**Planning Department
Transportation Development Services**

April 13, 2015

**Re: Innova Plaza
401 Eubank Blvd., SE
Traffic Circulation Layout
Engineer's/Architect's Stamp dated 4-7-15(L20-D067)**

SHEET NUMBER
C-1.0

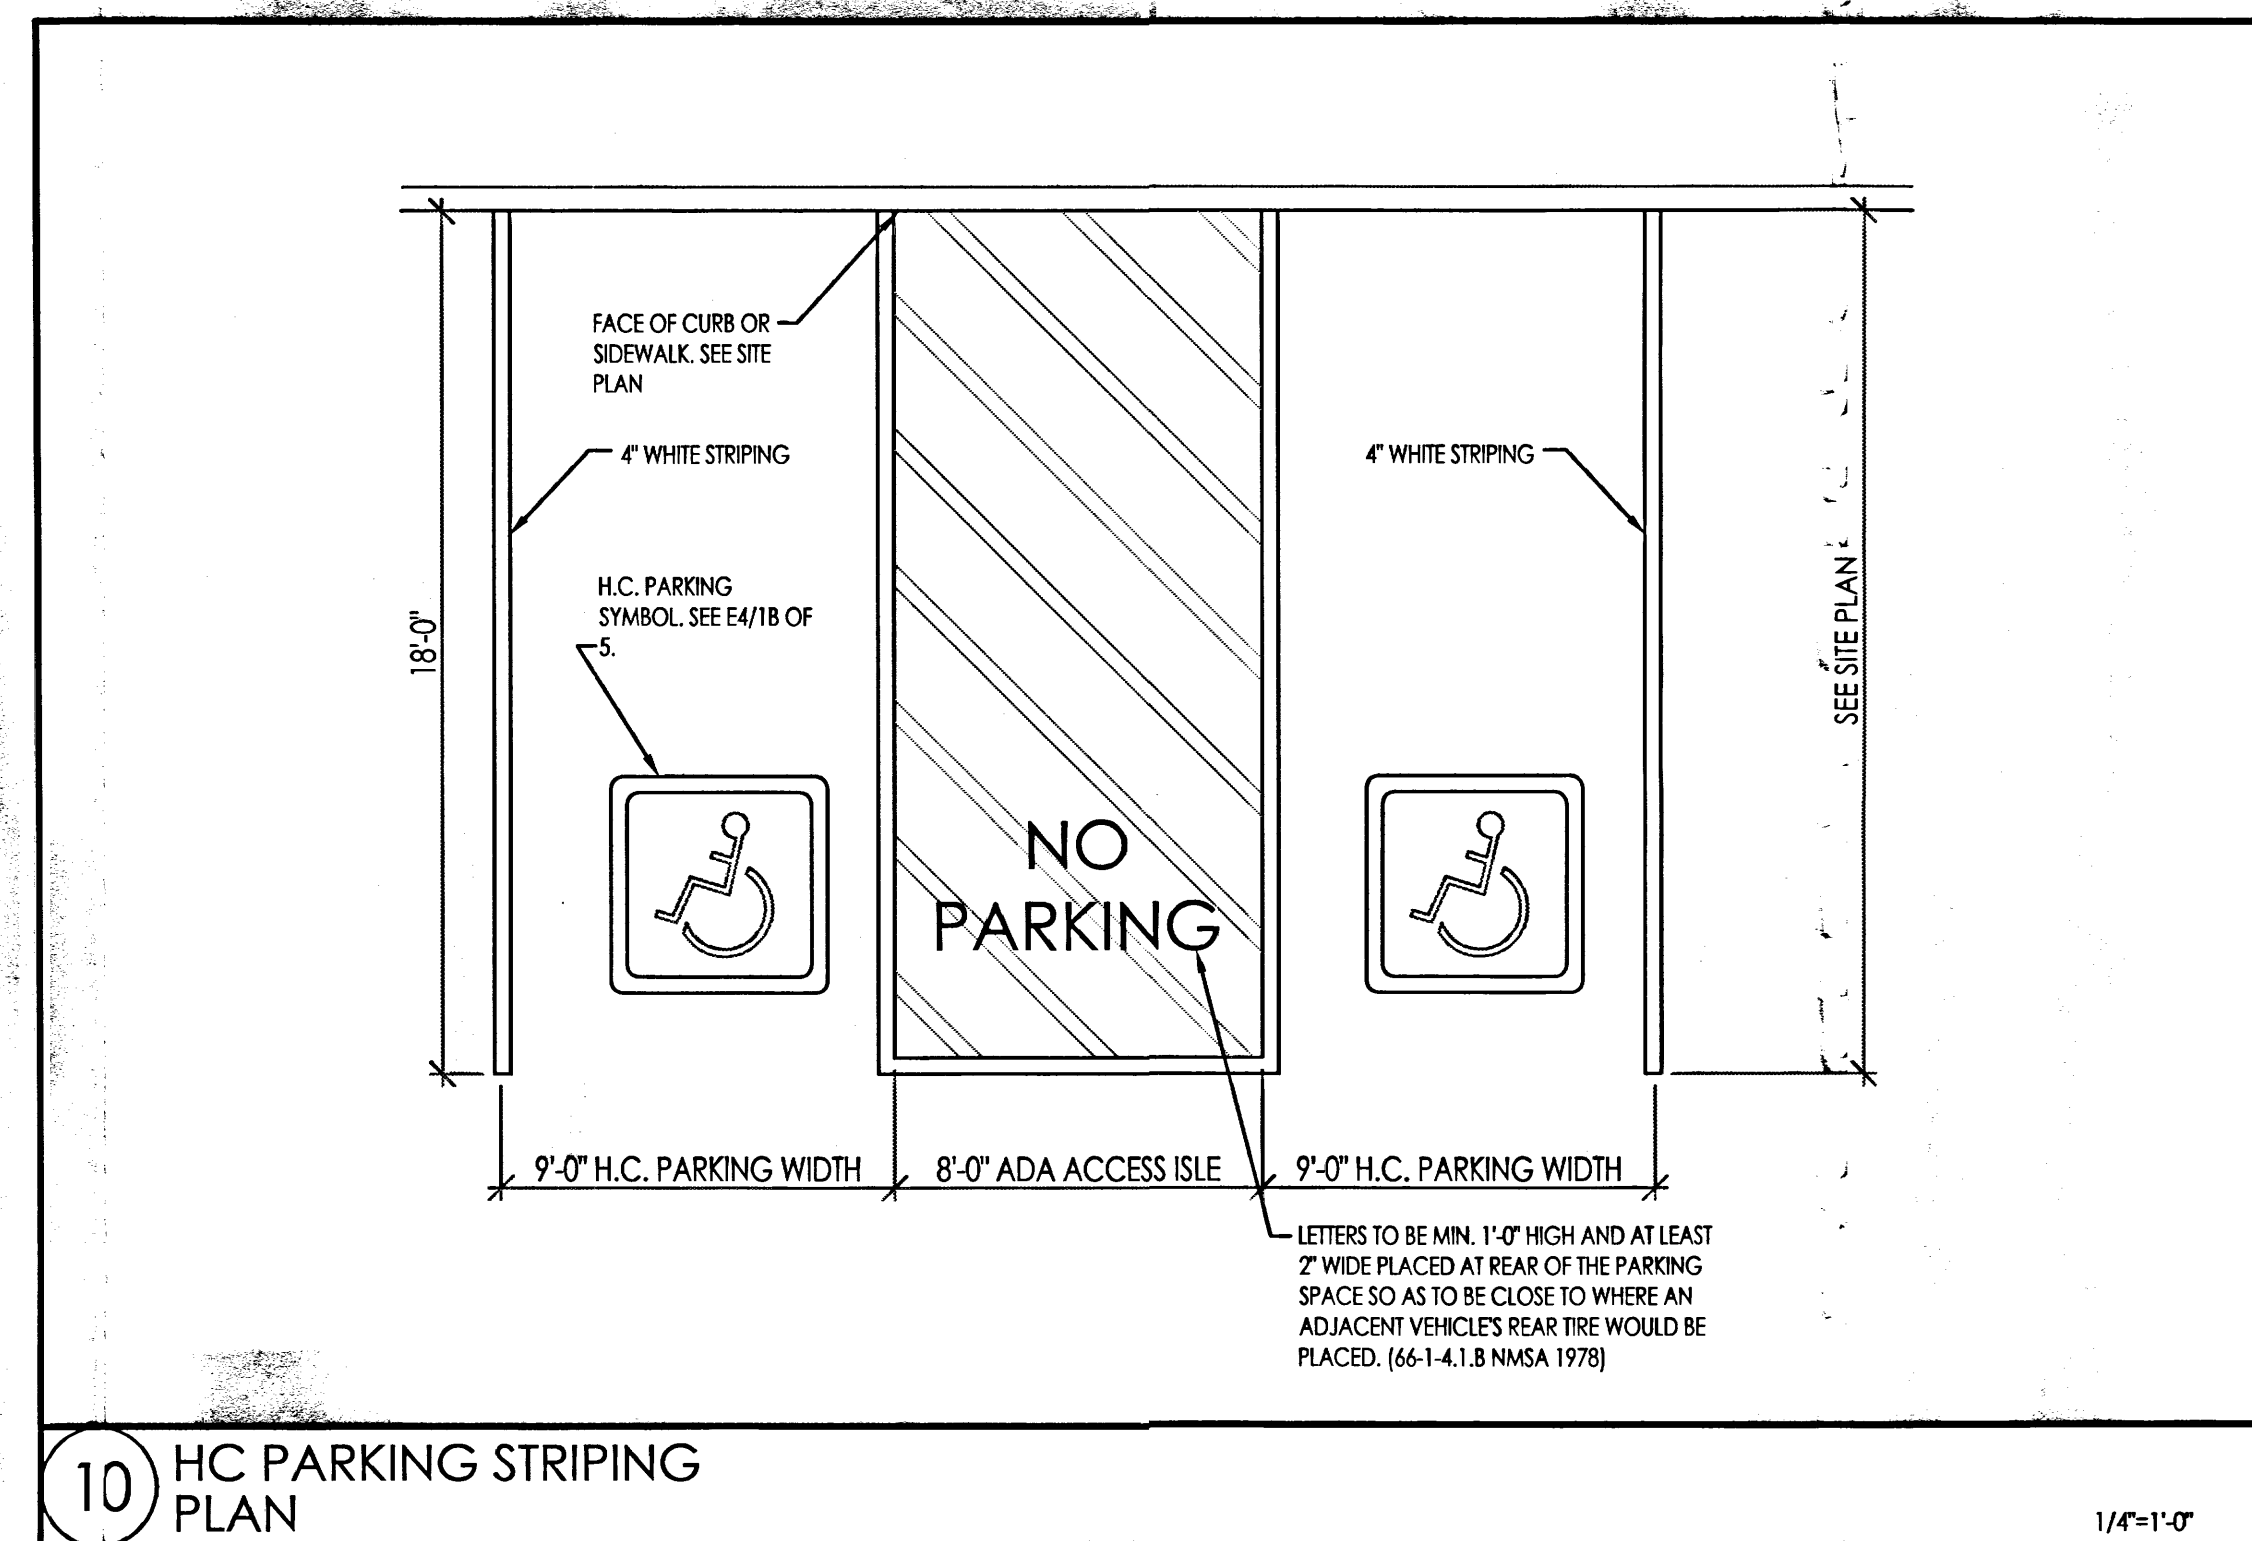
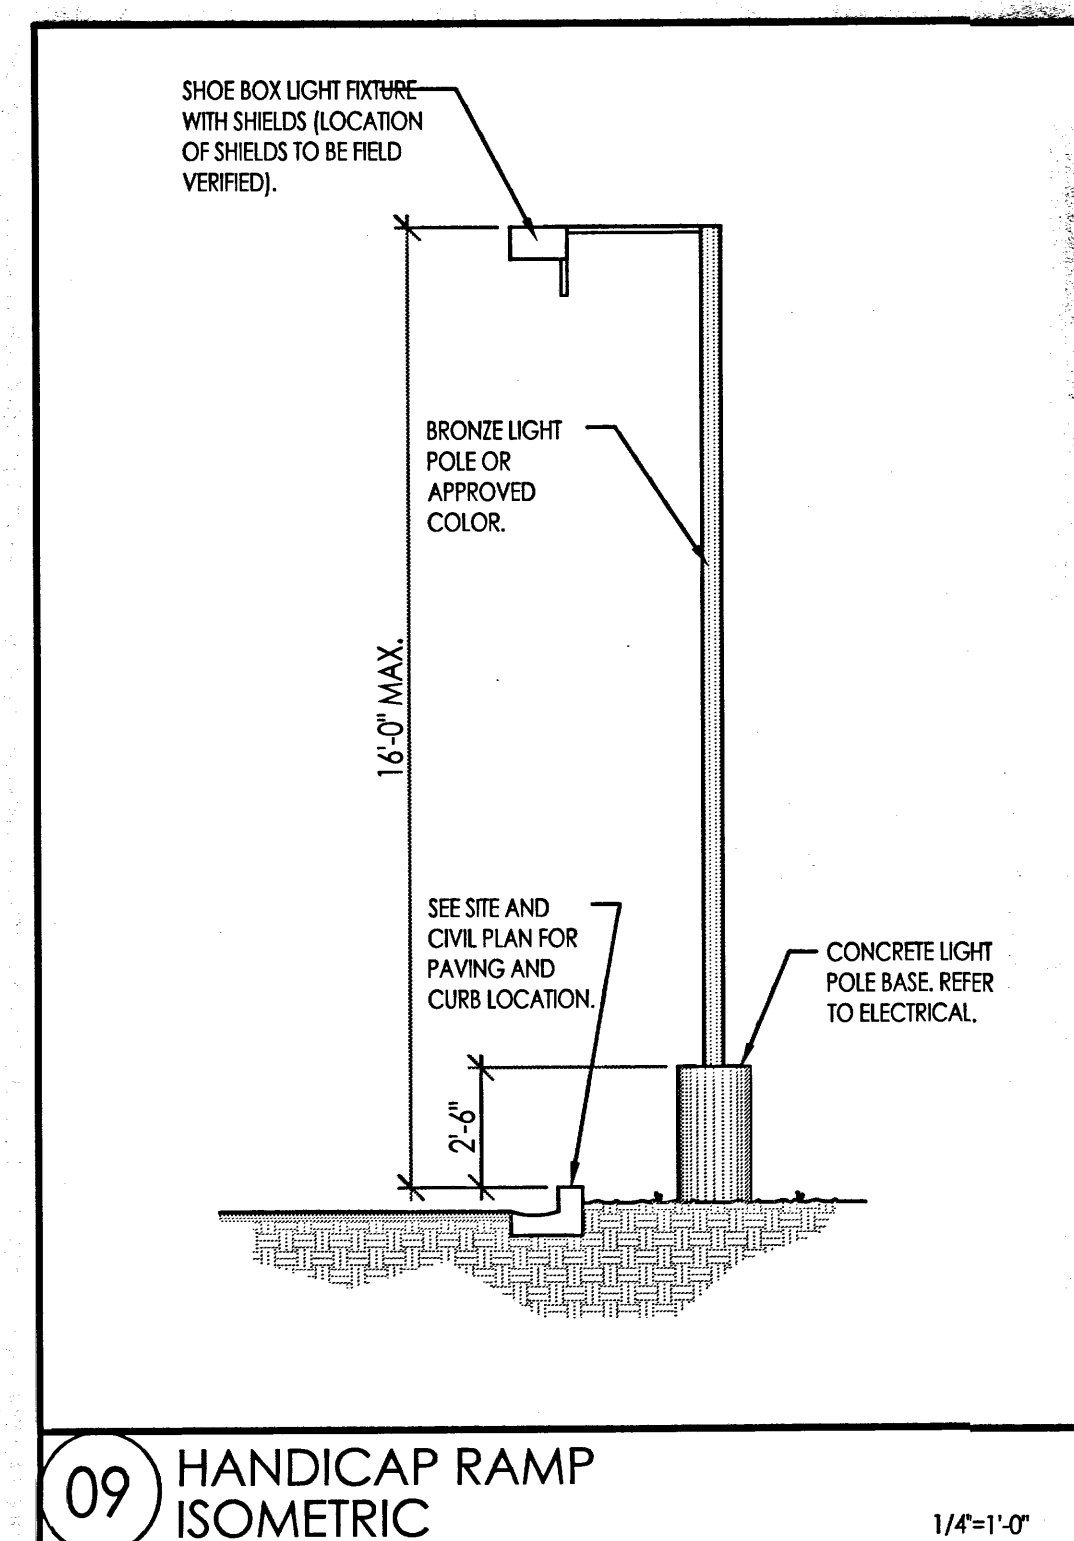
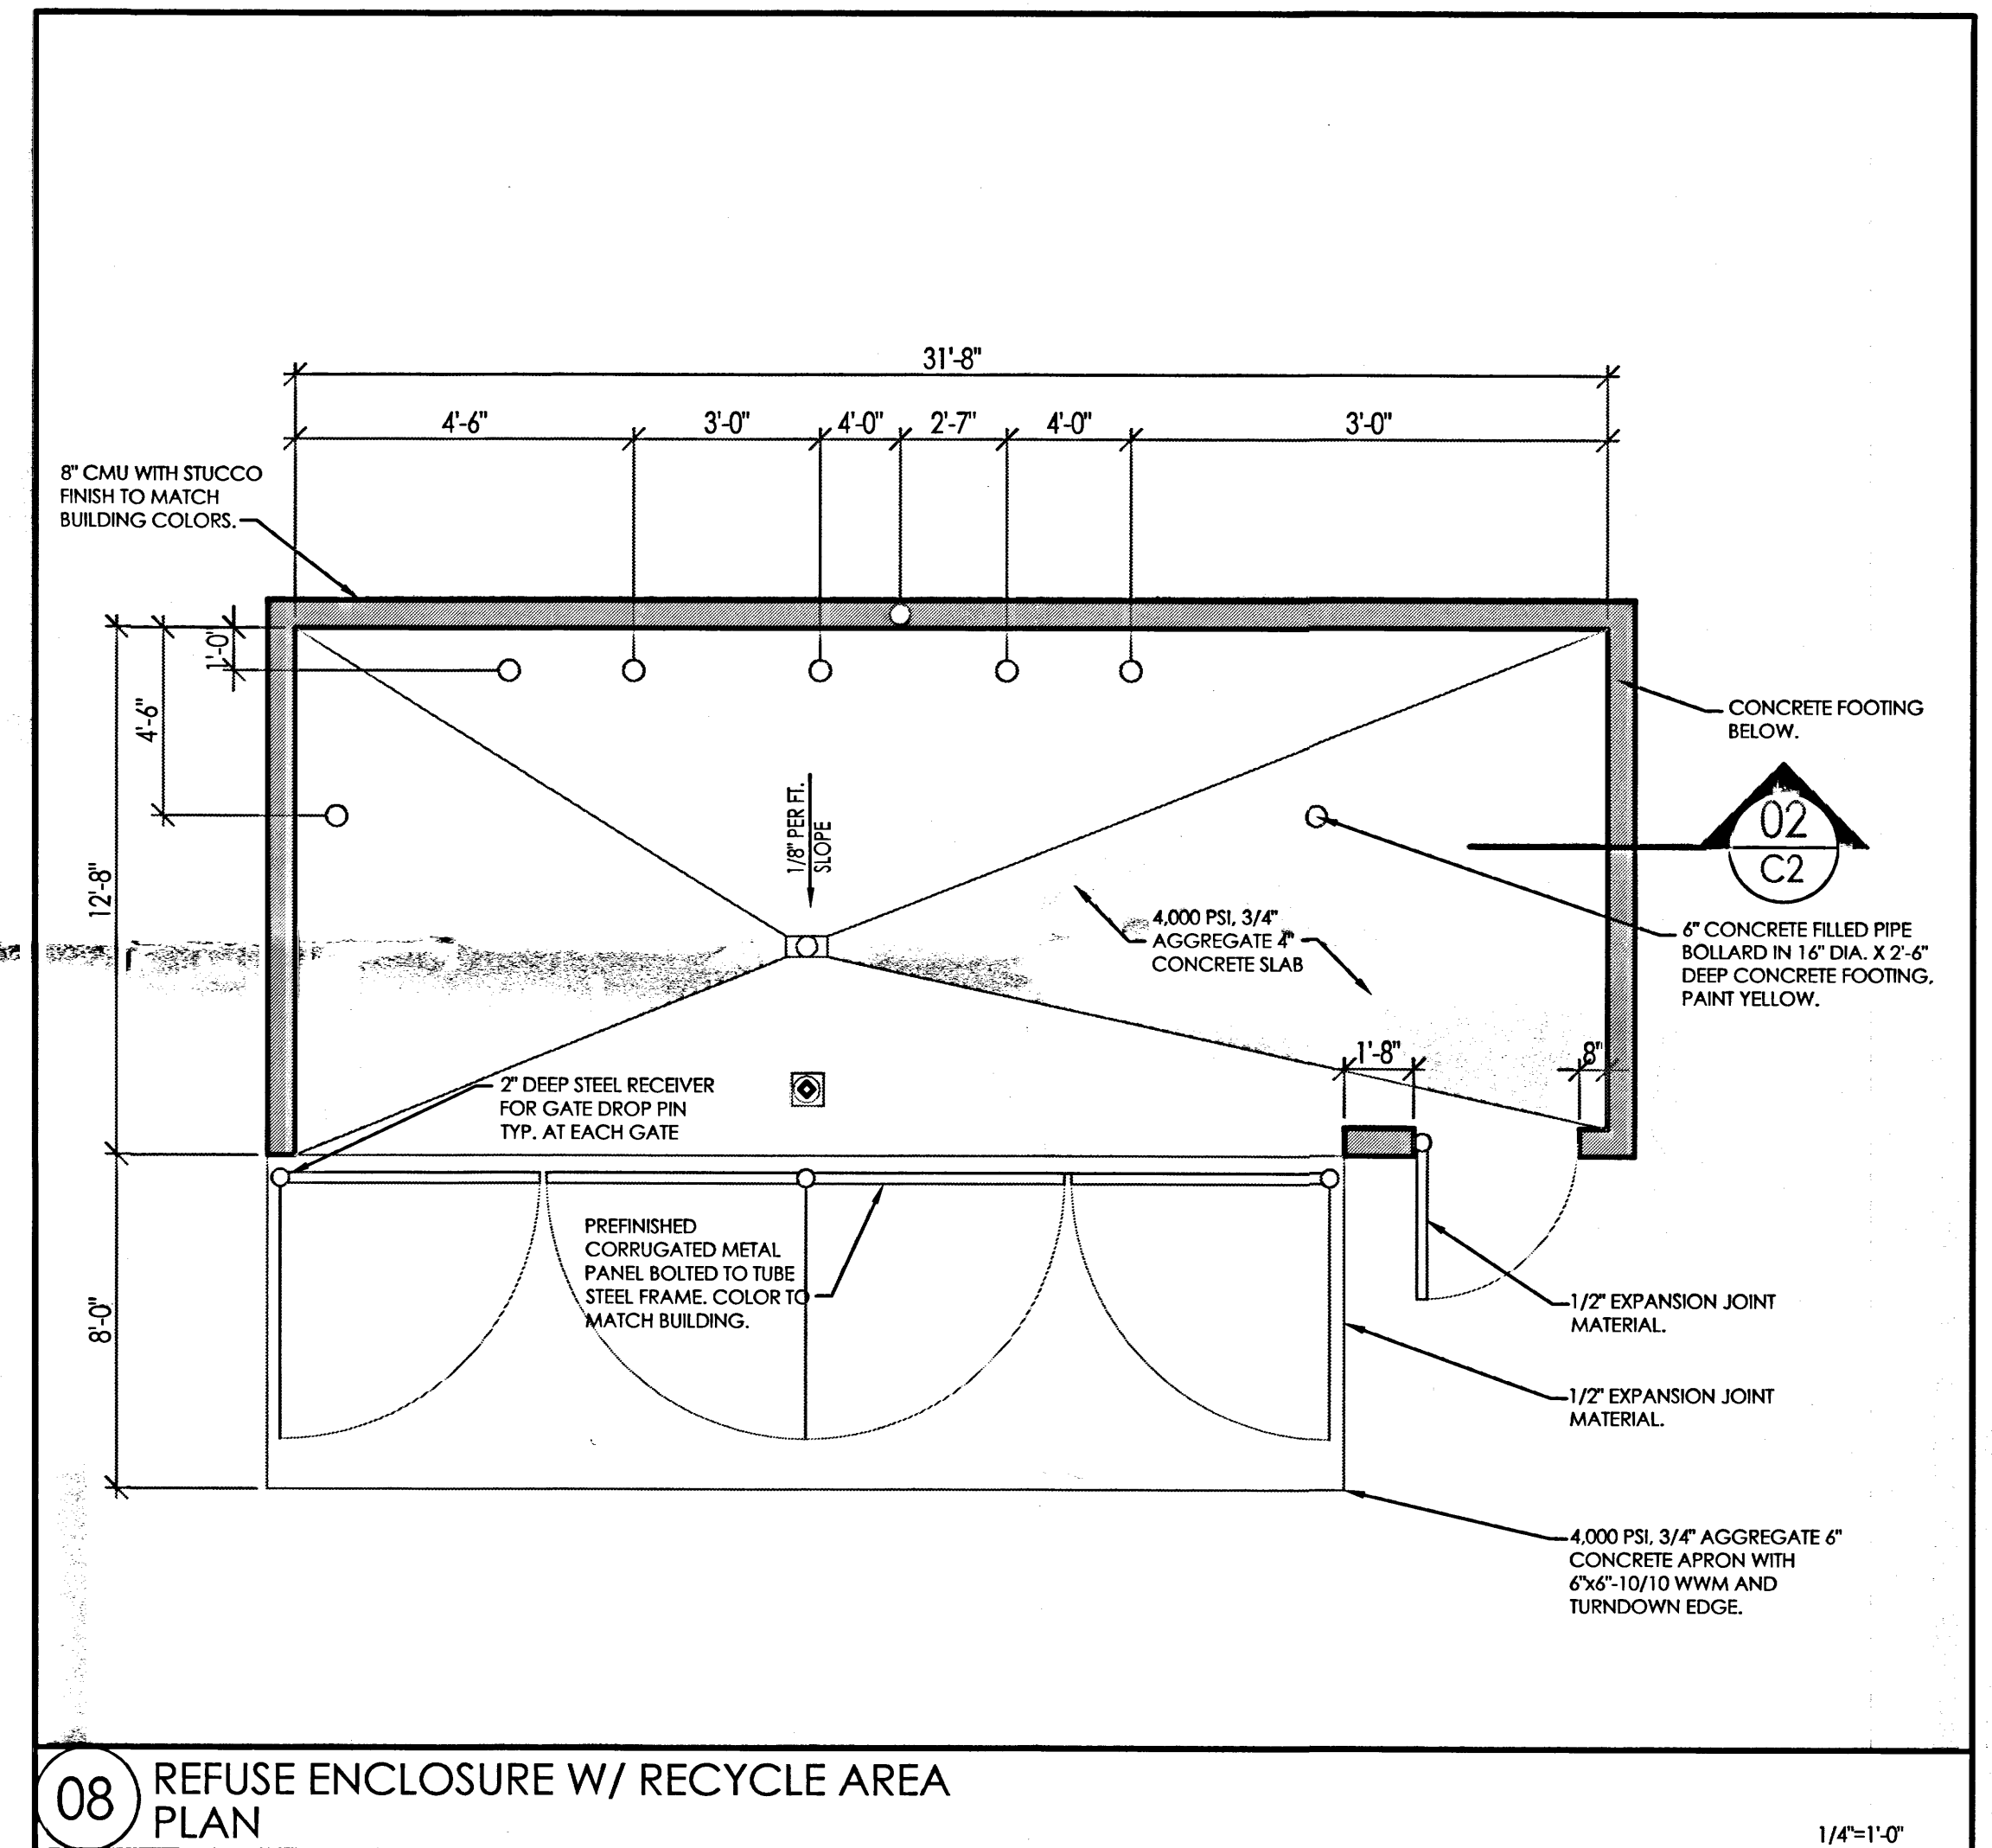
1. Upon review, re-platting of property will be required, so application must be submitted through the DRB Process for approval. If this is complete provide, please the DRB Project number.

2. Label the compact parking spaces by placing the words "**COMPACT**" on the pavement of each space.
3. Please dimension and detail all handicap and pedestrian walkways.

4. The ADA access aisle shall have the words "**NO PARKING**" in capital letters, each of which shall be at least one foot high and at least two inches wide, placed at the rear of the parking space so as to be close to where an adjacent vehicle's rear tire would be placed. (66-1-4.1.B NMSA 1978)

5. Design delivery vehicle route needs to be shown.
6. Service vehicle and/or refuse vehicle maneuvering must be contained on-site; provide a copy of refuse approval (if applicable).

7. Please show the "Clear Site Triangle" at the two entrance points per D5, Chapter 23 of the DPM.
8. Please include a copy of your shared access and parking agreement with the adjacent property owner. (If applicable)

10. Unused curb cuts must be replaced with sidewalk and curb & gutter. A build note must be provided referring to the appropriate City Standard. Please add detail of existing curb cuts on Trumbull Ave. and Bell Ave. that are to be removed and replaced with sidewalk per COA Standard #2430.
11. Please include two copies of the traffic circulation layout at the next submittal.
